Our ref: NO/2015/107923/01-L01
Your ref: 3/2015/0462
Date: 15 June 2015

DEMOLITION OF INDUSTRIAL STORAGE BUILDINGS TO THE REAR OF 19-21 KING STREET AND REGENERATION OF THE SITE TO PROVIDE 3 NO. TWO-STOREY DWELLINGS - ONE DETACHED AND ONE PAIR OF SEMI-DETACHED 19-21 KING STREET, WHALLEY

Environment Agency Position

3980 - 04A.

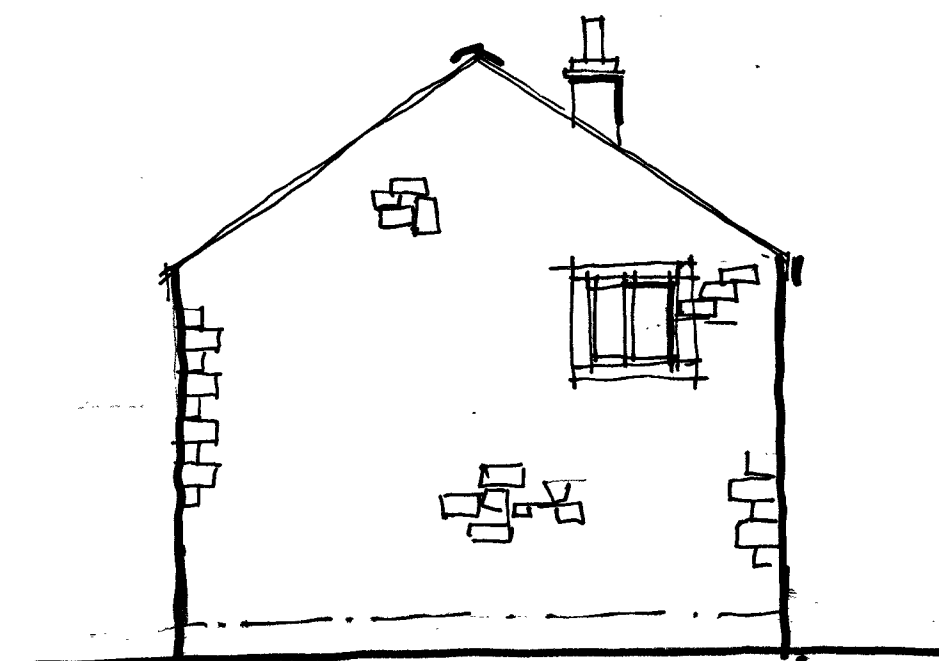
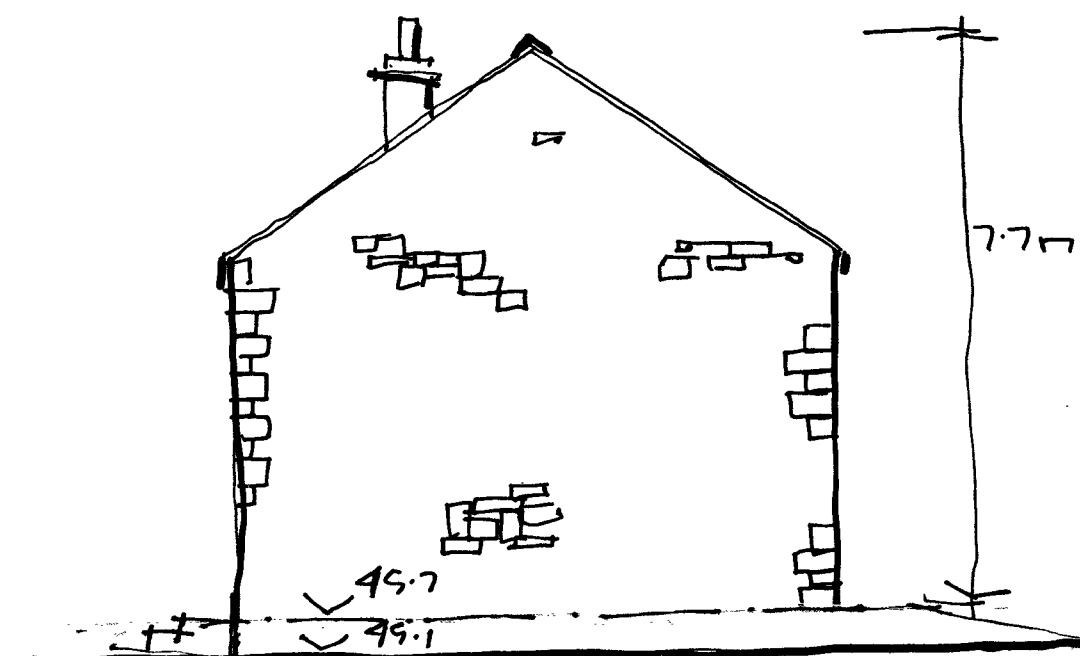
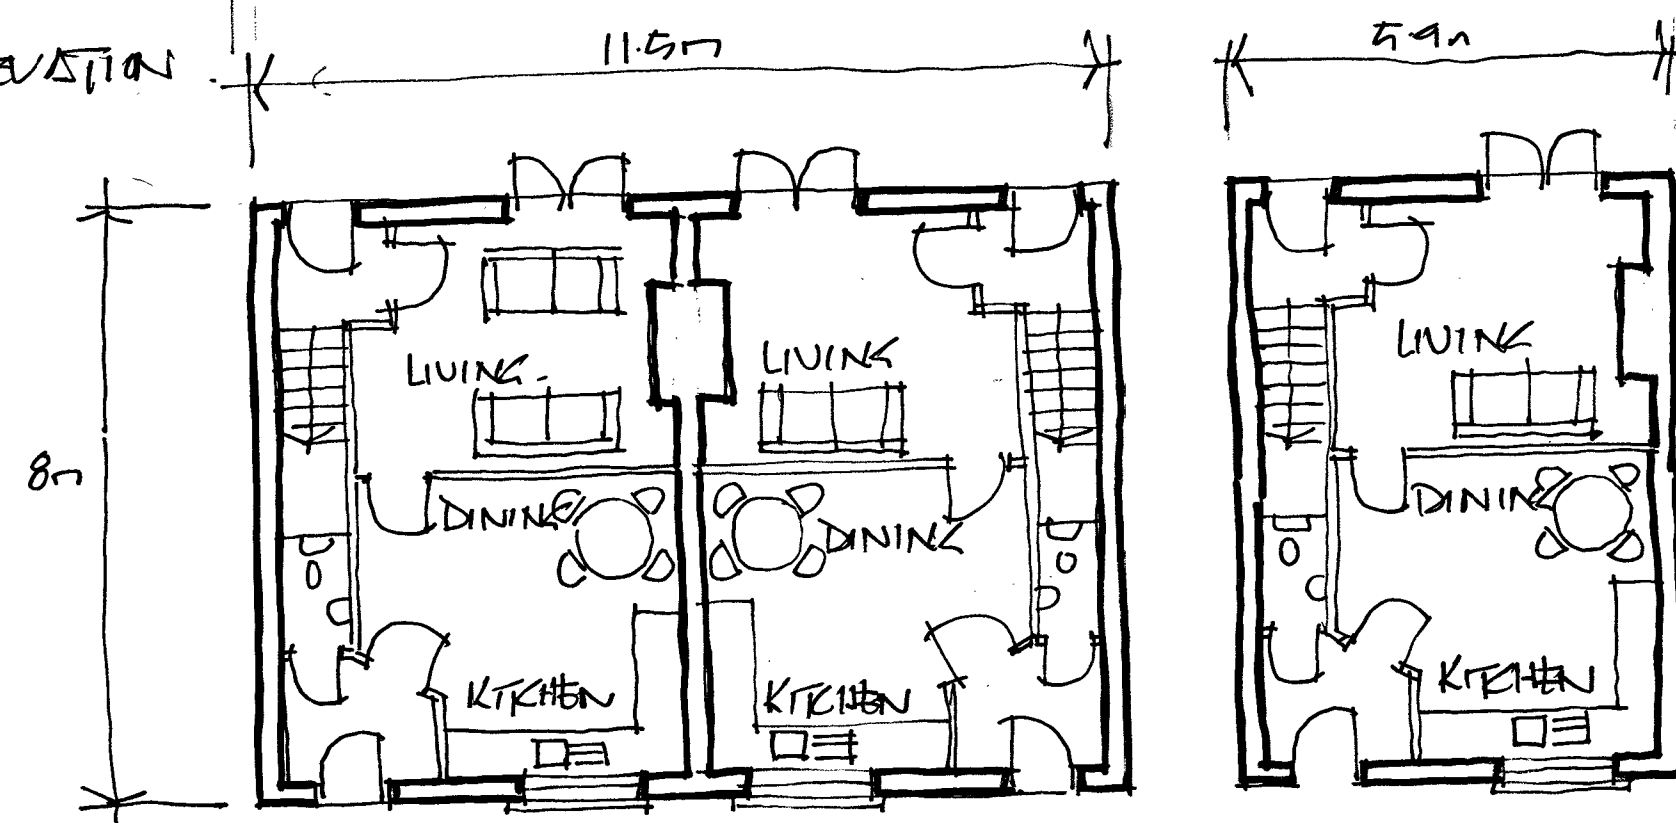
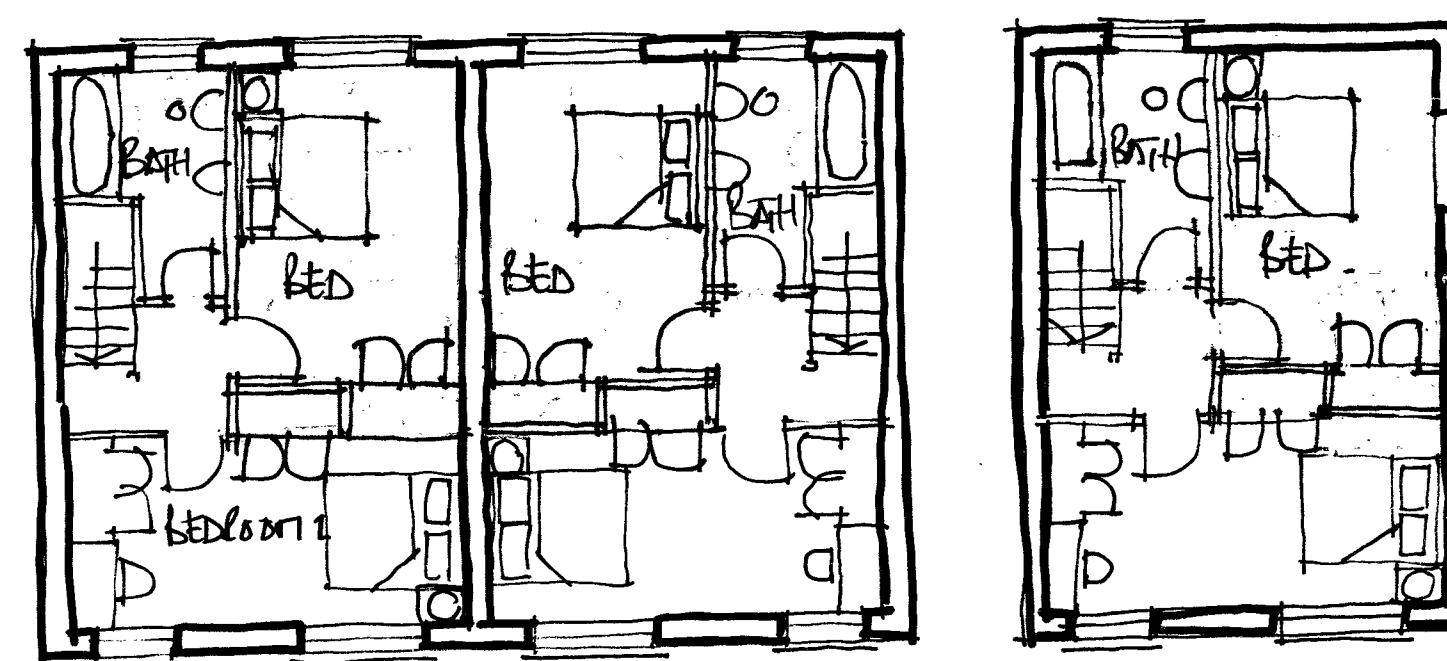
The majority of the site is within Flood Zone 2 with only small areas in Flood Zone 3. In this case we would recommend finished floor levels at 300mm above existing ground levels. The existing ground levels should be given in metres above Ordnance Datum (mAOD).
